Please ask for: Nicola Moore
Email: nicola.moore@arun.gov.uk
Telephone: Ext 37944
Our Ref: AW/230/20/HH
Your Ref:
Date: 5th October 2020

Application for Planning Permission for Works or Extension to a Dwelling

Development: Extended dropped kerb
Location: 17 Grosvenor Gardens Bognor Regis PO21 3EY

17 Grosvenor Gardens, Bognor Regis, PO21 3EY

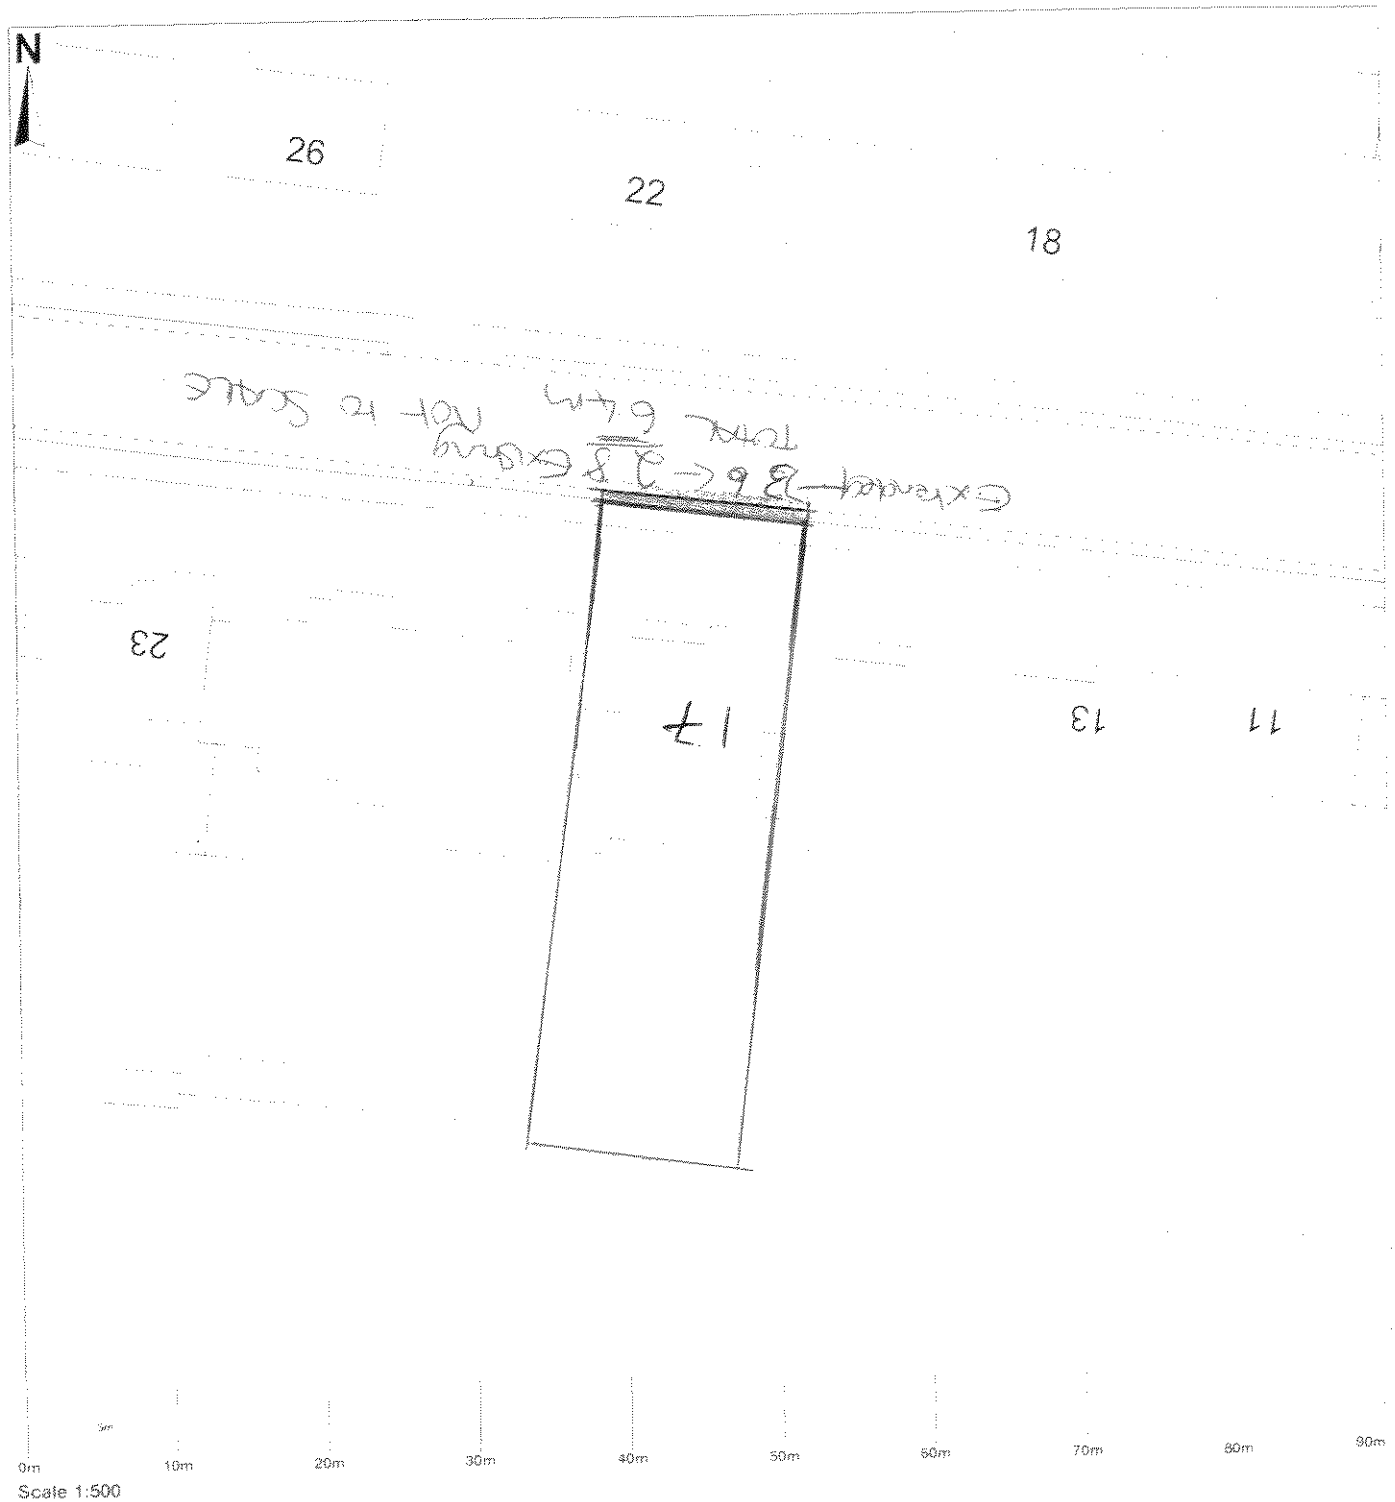
Block Plan

Please clearly edge the application site/property boundary in red. Further details of what must be included on the plan can be found in the Validation Requirements List.
